5th May 2019

Objection to Planning Application Number 2019/60/91141W

We would like to raise our objection in relation to the proposed single dwelling on land adjacent to 320 New Hey Road, Oakes, Huddersfield, HD3 4GQ

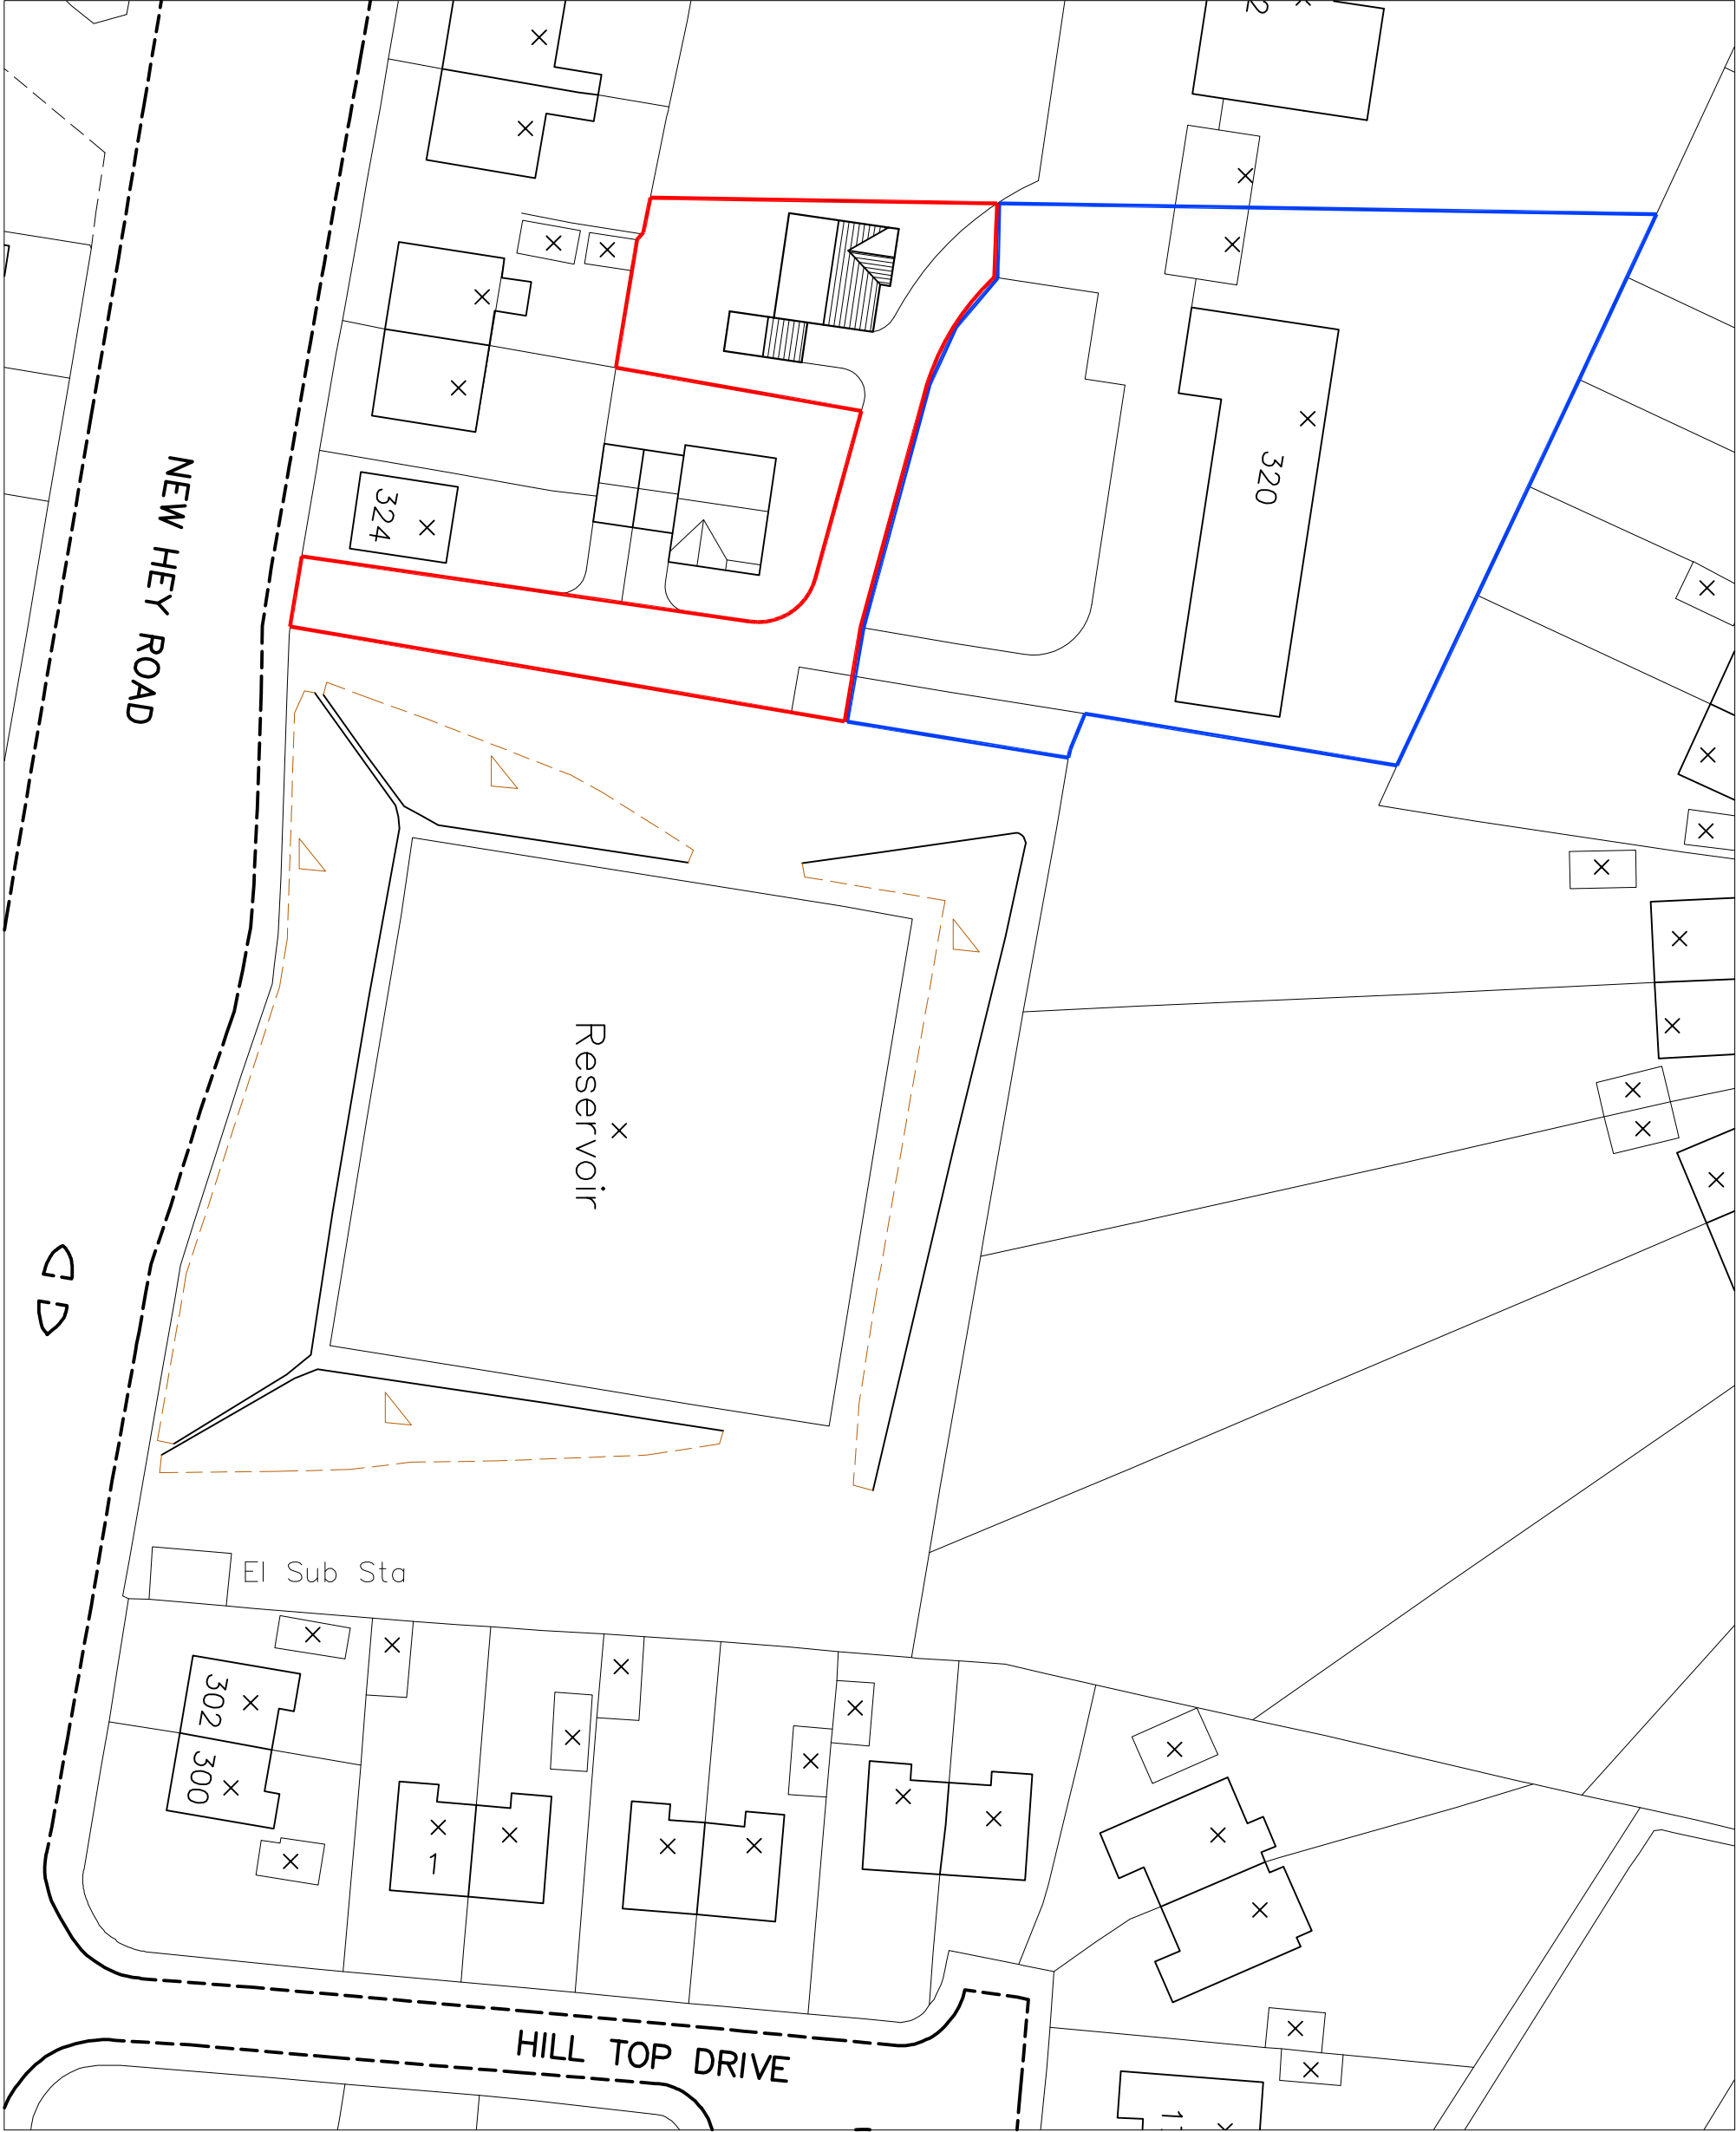
- The house to the assumed east of the proposed dwelling is orientated at an angle and is not parallel to the houses to New Hey Road as shown. This would reduce the actual amenity space of this property which will lose significant private space due to being overlooked.

- The proposed plan shows trees in locations that do not correspond with the locations on site thus not giving a true picture as to where the house will be sited.

- House Number 330 New Hey Road has an extension to the rear which is closer to the proposed dwelling than is currently indicated. This would reduce the actual amenity space of this property which will lose significant private space due to being overlooked.

- The ordinance survey is out of date with no license reference and is presumably being reused from previous applications.
- Due to the steep topographical position the dwelling would present as an overbearing dwelling on the remaining private amenity space of the immediate properties to the East and South.
-
